Application Number: S6/2012/0096/FP
Name: [Redacted]
Address: 10 Wilkins Green Lane
Hatfield
Herts
AL10 9RT
Comment Type: Object

Comment: As the owners of no.10 Wilkins green Lane we would like to give our objections to the proposed extension/development of no. 9.

TITLE  
PROPOSED  
BLOCK PLAN

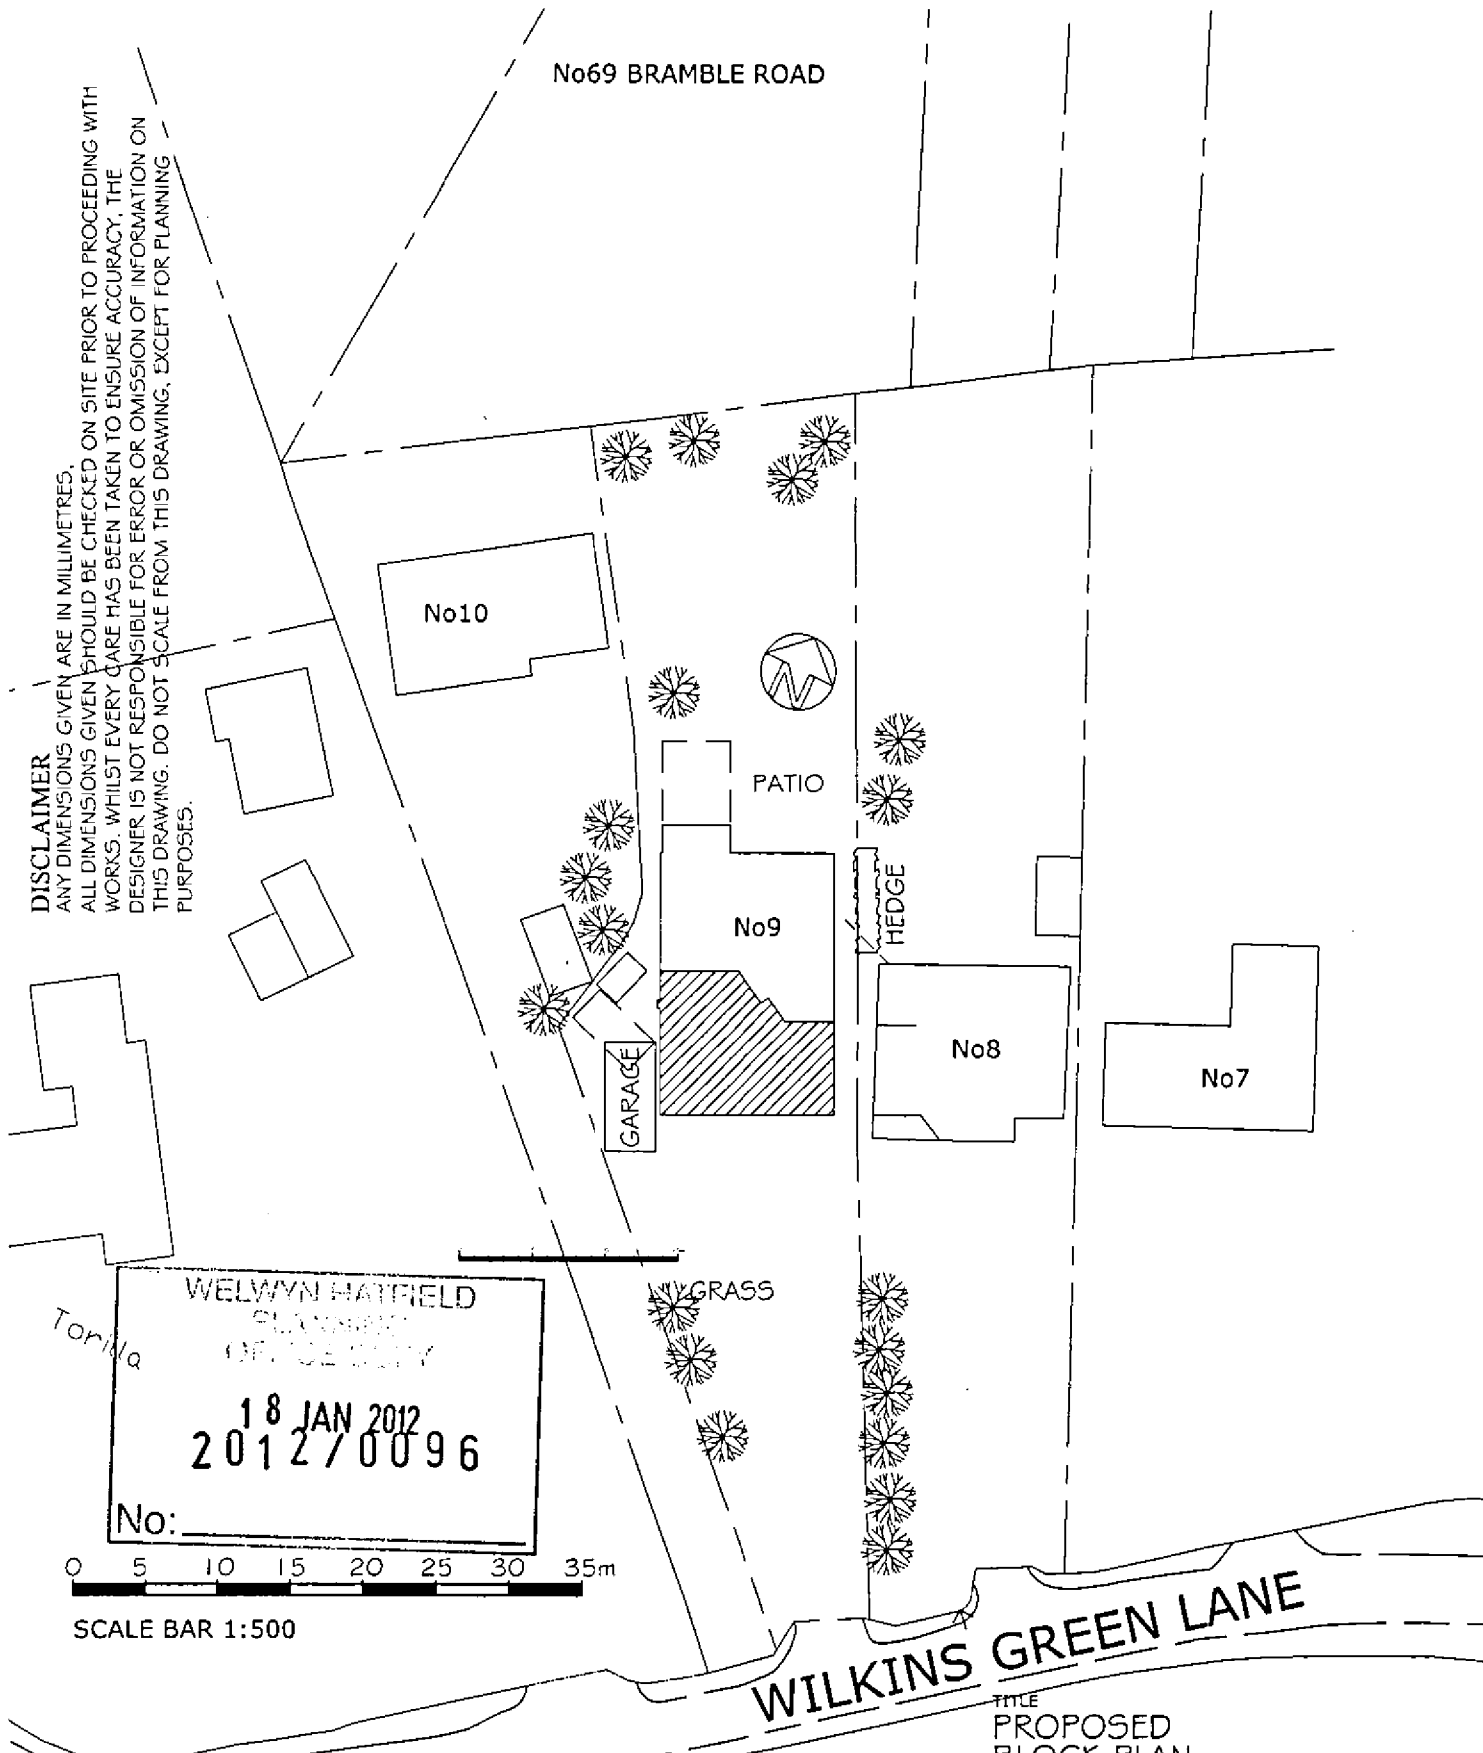
As we have an easterly facing chalet bungalow surrounded by trees, we do suffer with poor light. The proposed position of the 2-3 story house will be directly in front of our home, overshadowing the front aspect. This will no doubt have a detrimental effect on the natural light in our front rooms. Due to the dramatic increase in height of our neighbours proposed home I am especially concerned for our ground floor rooms - lounge, entrance hall and ground floor bedroom.

We feel that the proposed extension/development to take the property from a 3 bedroom bungalow to a 6 bedroom 2-3 story house is much too large a project for the size of the plot and will be very overpowering and highly imposing to our property behind. The project will give around a 300% increase in square footage. Our outlook will alter from fields and trees to be an enormous expanse of brickwork towering over us. This is contrary to policy D1 of the district plan. The proposal is out of character and context for the area.

- i) extensions should be designed to complement and reflect the design and character of the dwelling and be subordinate in scale;
- ii) the extension must not reduce the space around the dwelling to such an extent that the dwelling looks cramped on its site. The spacing of buildings adjacent to and in the locality of the site should be reflected;
- iii) the extension should not cause loss of light or be unduly dominant from adjoining properties, as a result of either the length of projection, the height or the proximity of the extension.

TITLE
 PROPOSED
 ELEVATIONS
 ADDRESS
 9 WILKINS GREEN LANE
 HATFIELD, AL10 9RT
 CLIENT
 Mr. & Mrs TITMUSS
 SCALE
 1:100 @A3
 DRAWING No.
 WGL 102-5
 DATE
 JAN 2012
 REV.
 -

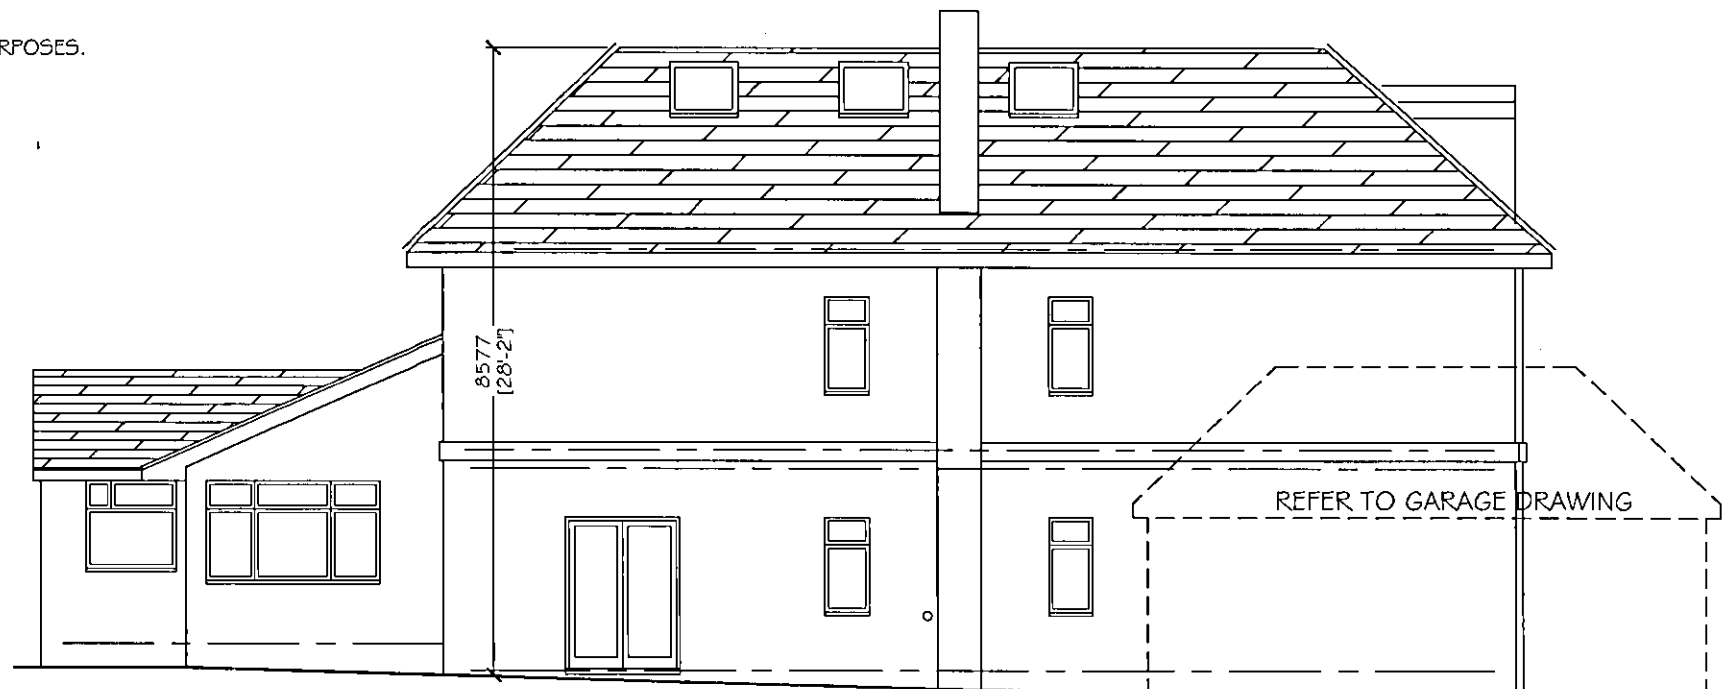
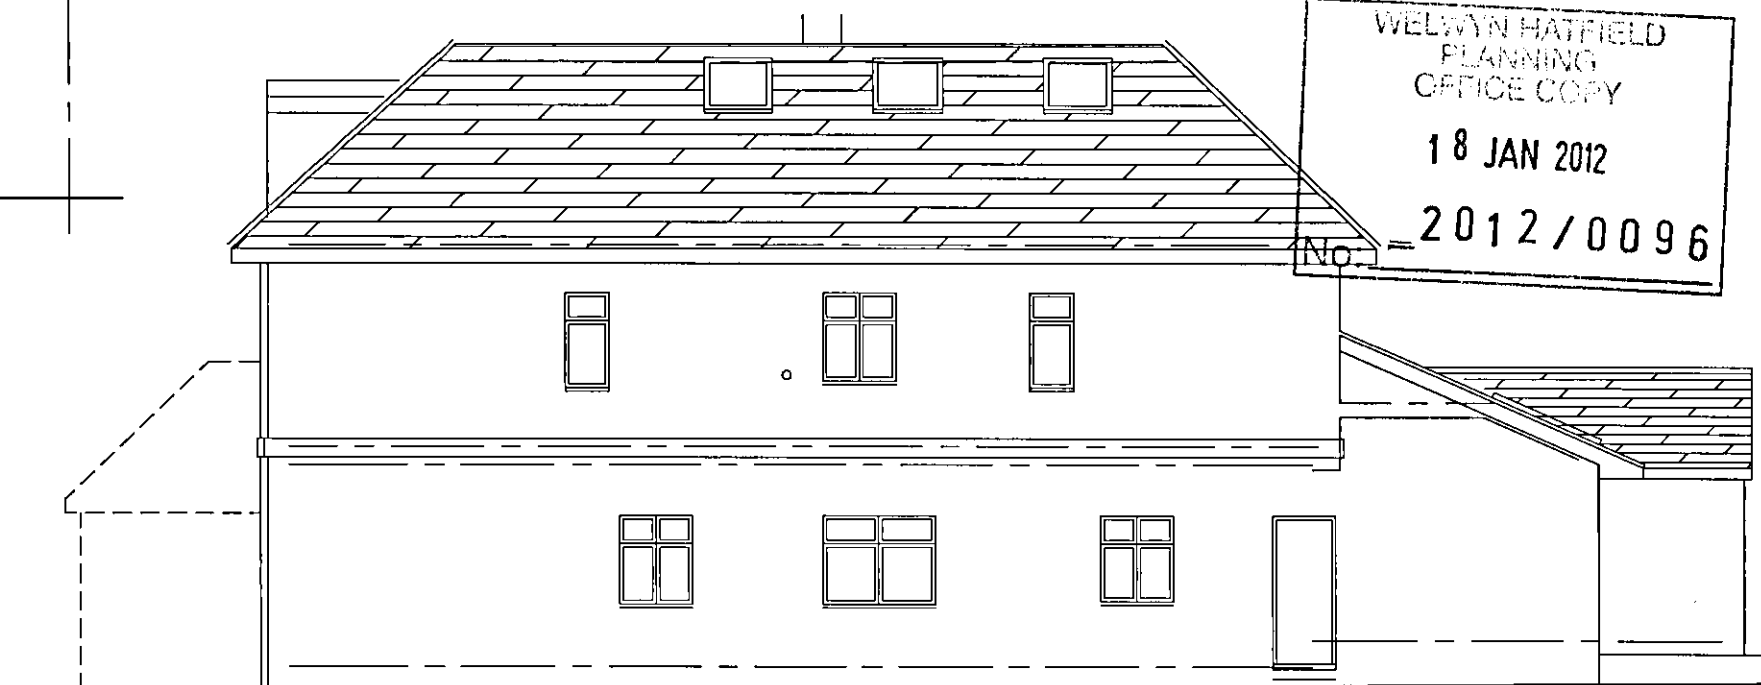
The proposed build description does not give a full picture of the enormity of the changes to the existing building. Not only is it proposed to add a 2-3 storey front extension, but the existing bungalow will also be raised to 2-3 storey, thus doubling the depth of the property and almost trebling the ridge height.

The best time of the day in our home is the morning. As the sun rises in the east, the lounge and front bedrooms are flooded with natural sunlight and warmth. The proposed front extension is in a direct line to the east, and the height will mean the sun will have to be high in the sky before it touches our windows. There will also be a big impact on the front garden which will be in shadow most of the day.

The rear and side windows of the proposed project face the front of our home and garden. Therefore we will have a direct view into their back bedrooms and they will have a view into our bedrooms and reception rooms. This will mean that we will both lose privacy. This is contrary to policy D1 of the district plan and paragraph 5.7 of the current SPG. The submitted plans are misleading in that they include trees on our land that give the impression of seclusion, but this is not the case.
